September 20, 2019

**ENTECH**  
ENGINEERING, INC.

Re: Soil, Geology and Geologic Hazard Evaluation  
Meridian Ranch – Rolling Hills Ranch, Filings 1 through 4  
SE of Sunrise Ridge Drive and Rex Road  
El Paso County, Colorado

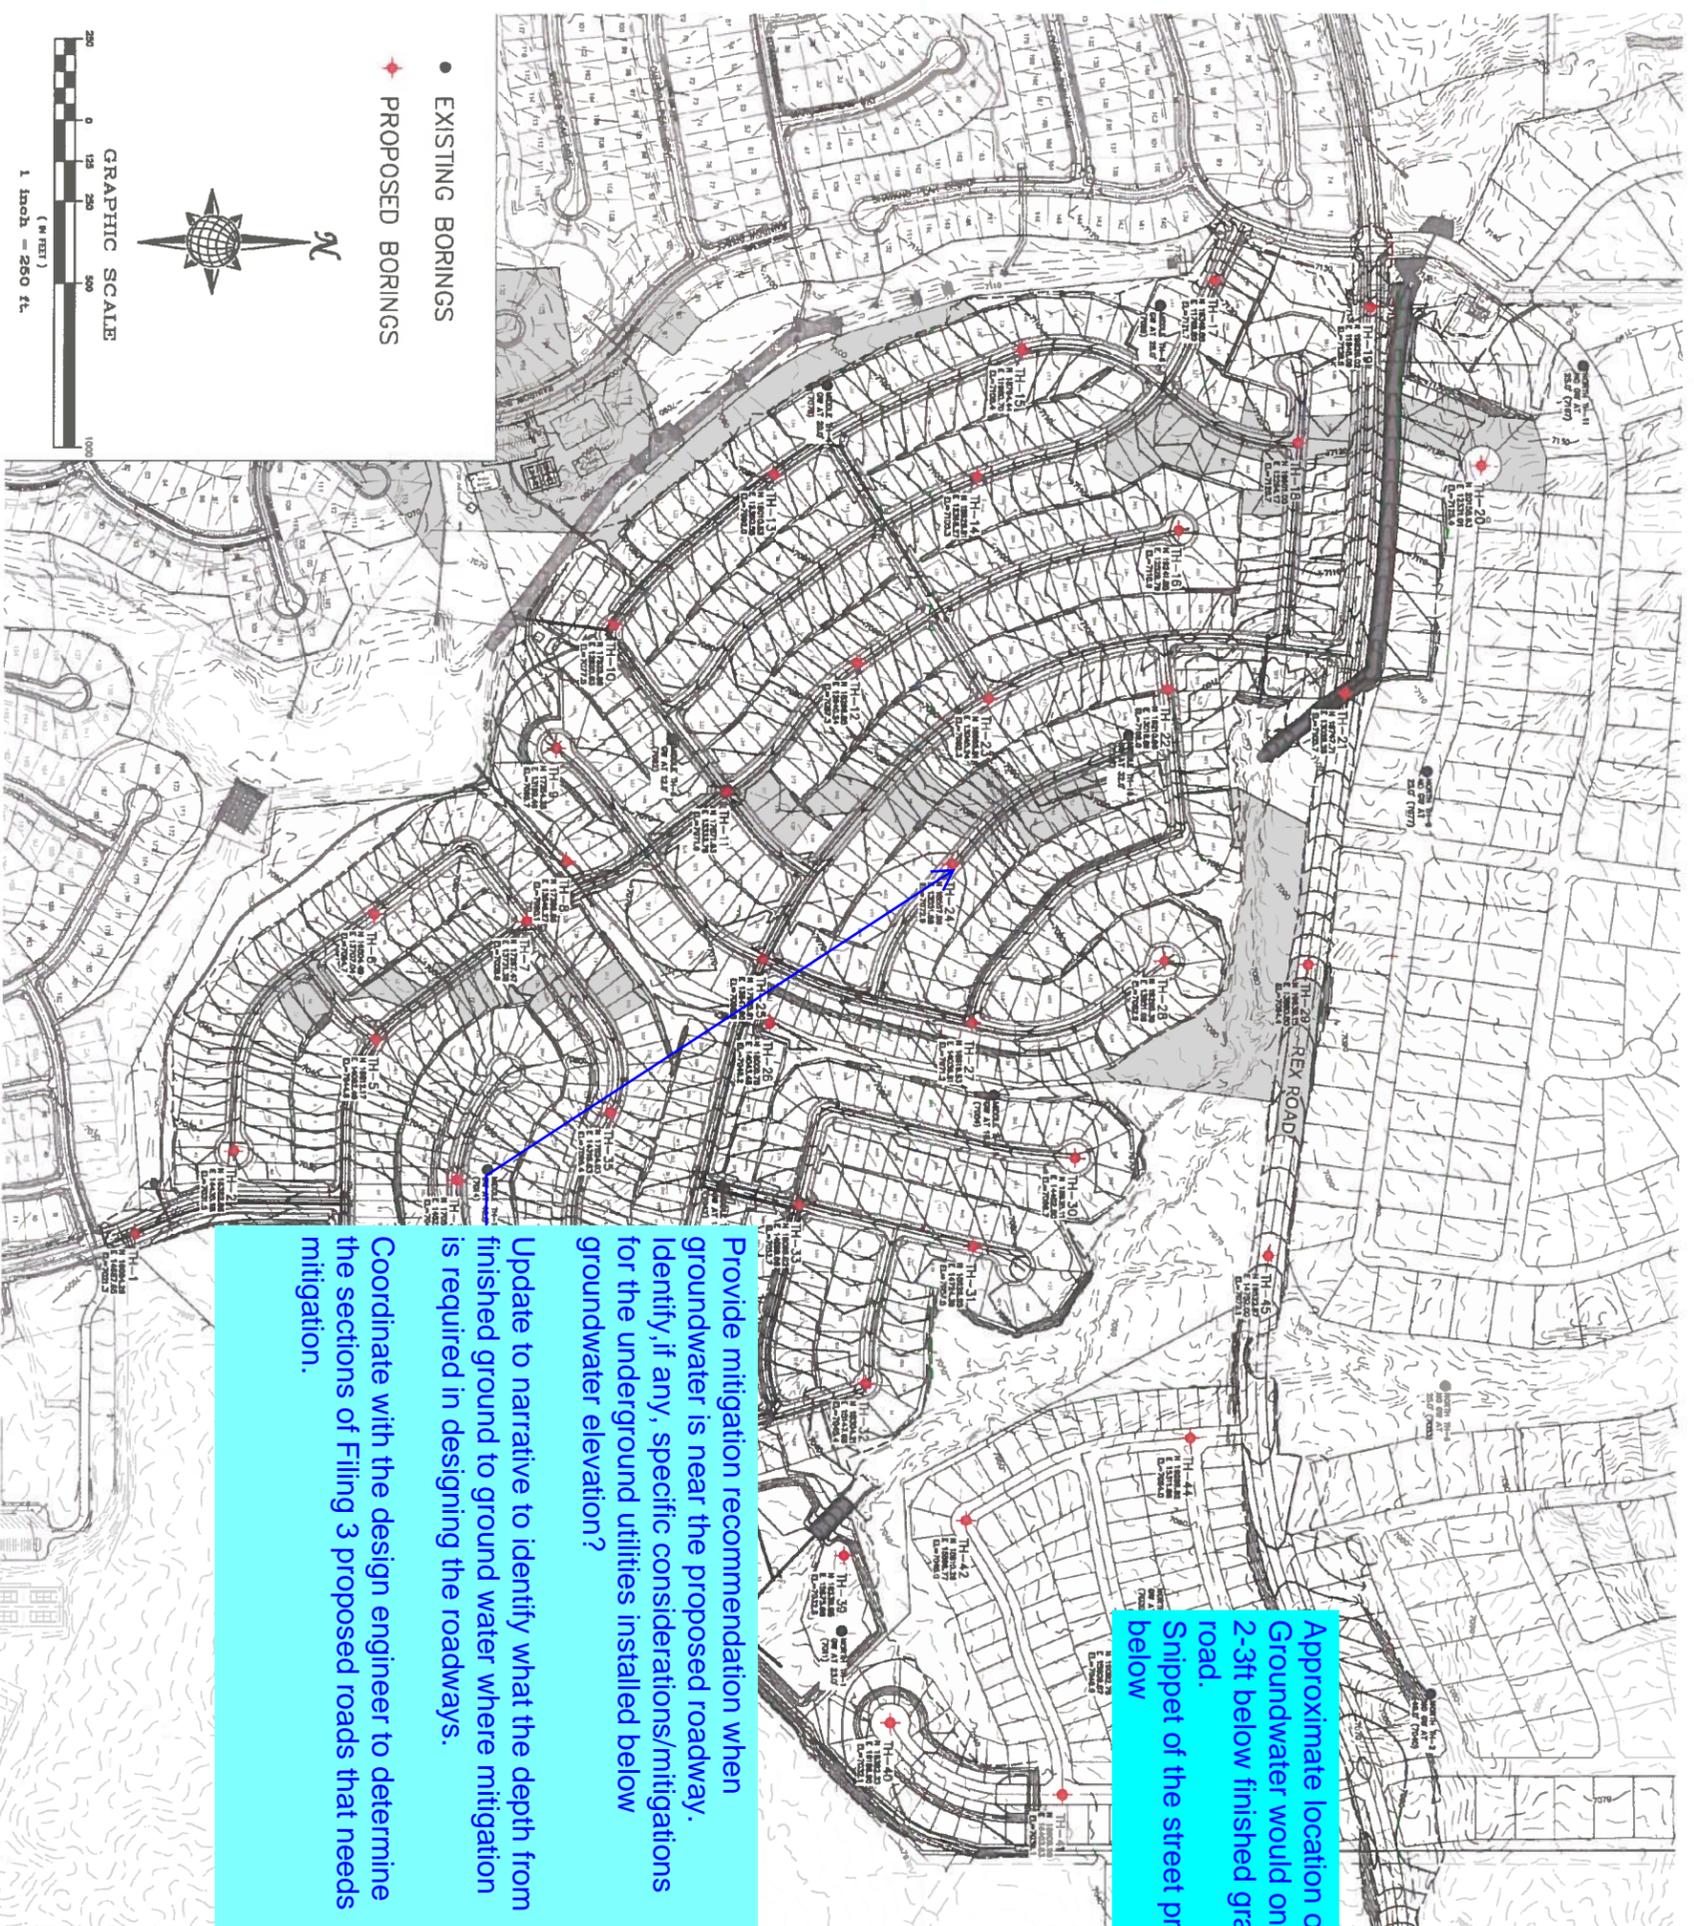
Approximate location of TB24. Groundwater would only be around 2-3ft below finished grade of the road. Snippet of the street profile shown below

Provide mitigation recommendation when groundwater is near the proposed roadway. Identify, if any, specific considerations/mitigations for the underground utilities installed below groundwater elevation?

Update to narrative to identify what the depth from finished ground to ground water where mitigation is required in designing the roadways.

Coordinate with the design engineer to determine the sections of Filing 3 proposed roads that needs mitigation.

See attached letter for engineers response to this comment and updated borings for TH #23 & 33.
